**From:** [REDACTED]  
**To:** [Jones, Hefin](#)  
**Cc:** [REDACTED]  
**Subject:** ISH Meeting 26th February 2020 Turfhill Site Specific Plan  
**Date:** 02 March 2020 09:20:21  
**Attachments:** [The SLP - Response to SSP for Turfhill Site Plan 010320 AB,CT,KS.docx](#)  
**Importance:** High

**The SLP – The Heronscourt & Colville Gardens (the RAs) response to the Applicants Site Specific Plan for Turfhill Park APP 8.58 REP4-050**

Drawing title: **TURF HILL: CONSTRUCTION STAGE**

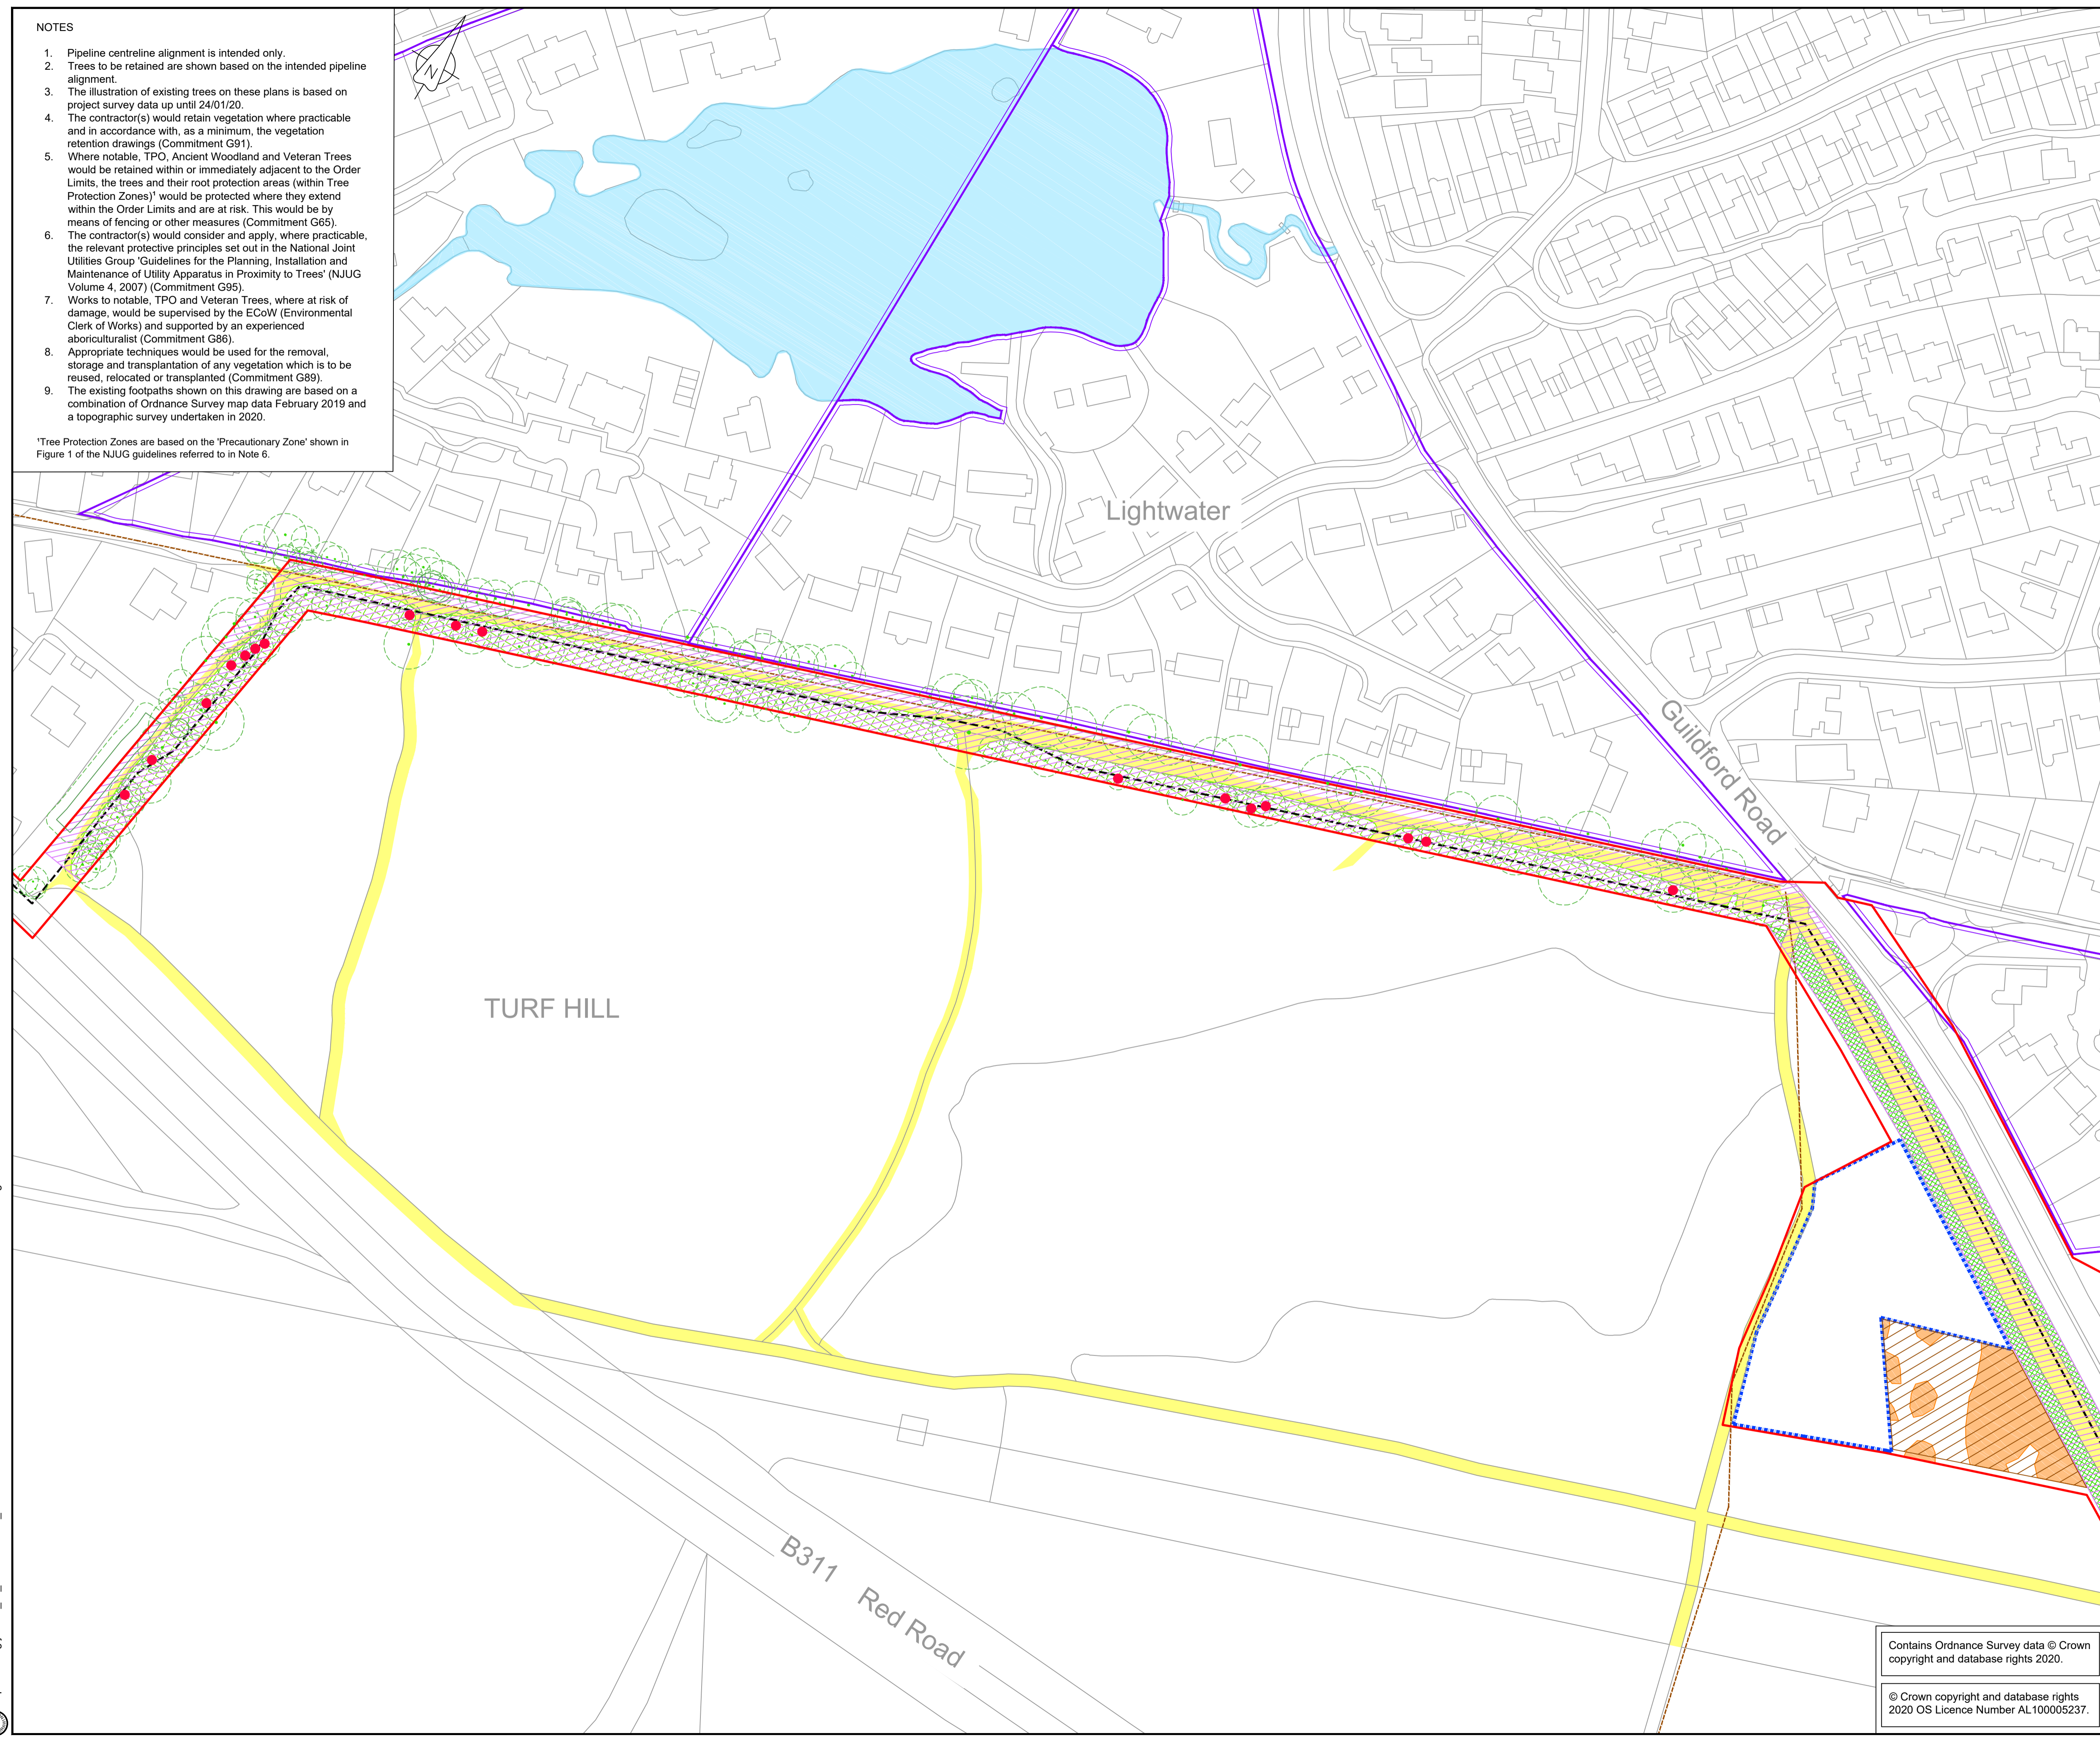
As has been covered in other submissions, the 17 trees referred to are those in only two sections of F1a+ and in excess of 250mm diameter.

An update on that is that the Applicant has come to realise the inadequacy of its Arboricultural Survey report and is presently surveying all three sections of the total route and all trees in excess of 75mm.

As the Applicant has committed to using this Standard, it is difficult to see how Open Cut methods can now be employed along F1a+, particularly with the RPA and root patterns present on this route as described in the following paragraph.

Additionally, as the pipe alignment has been designed to run along the southern edge of the Order Limits to avoid the roots of the Residents' trees on the northern boundary, the RPAs of the many significant trees bordering the southern edge of the Order Limits will be in play.

As a result, throughout most of F1a+, there will be complex root patterns which spread right across the width of the Order Limits. Add to that the factor of the water main discussed further below, and it presents an extremely difficult challenge for any contractor to meet without causing considerable permanent collateral damage to all bordering trees and probably also to the water main.

The water main's actual route along F1a has still to be identified so at this stage it is impossible for the Applicant to agree how and where it can lay its line.

As the water main has to cross from its entry point in Guildford Road on the southern side of F1a to somewhere near to its estimated 3 metre easement from the Residents' boundaries on the northern side and take account of a significant bend halfway along the route, it is inevitable, that one or two of the following will occur at various points;

- the Applicant will have to exceed its Order Limits
- the fuel line will be laid in very close proximity to the water main
- the fuel line will encroach on the easement of the water main
- the fuel line will need to cross the water main
- the fuel line will damage the roots of trees in Residents gardens

Drawing title: **TURF HILL: REINSTATEMENT**

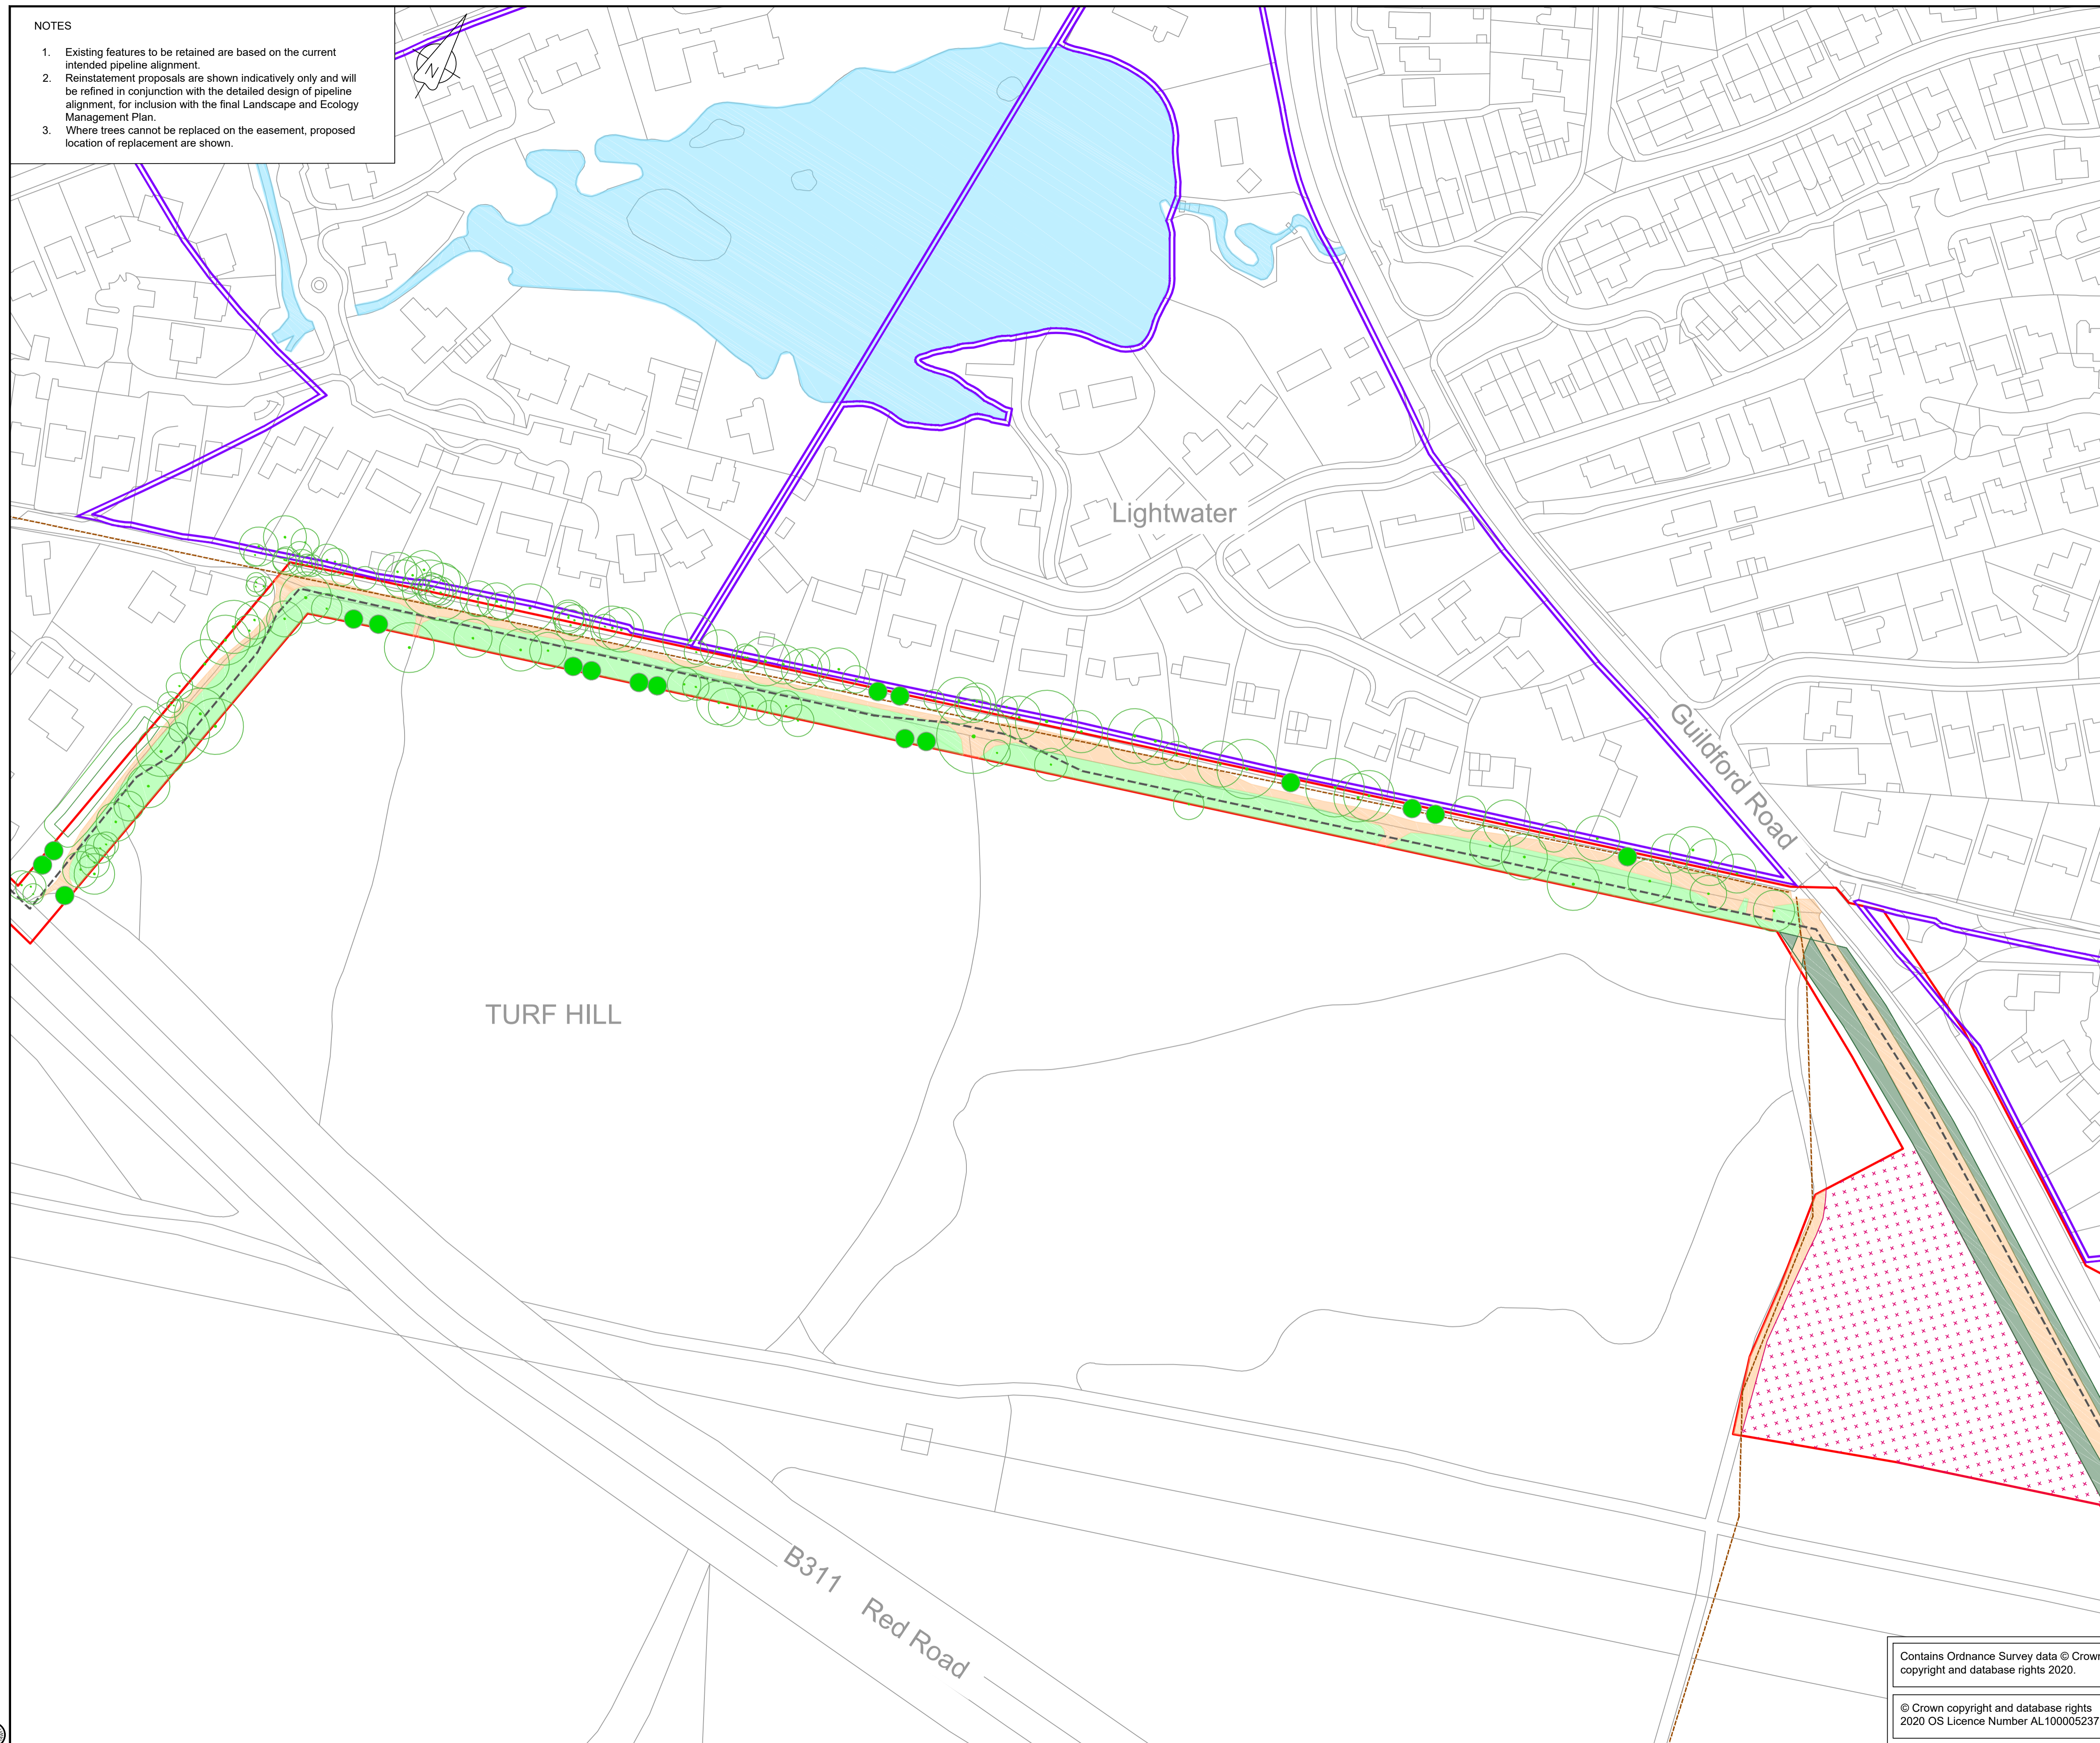
Given the narrowness of the Order Limits remaining after respecting the easements of both pipelines and the expected results of the new tree survey, there remains very little room, a strip of 1.5 to 2 metres to accommodate all of the replacement plantings.
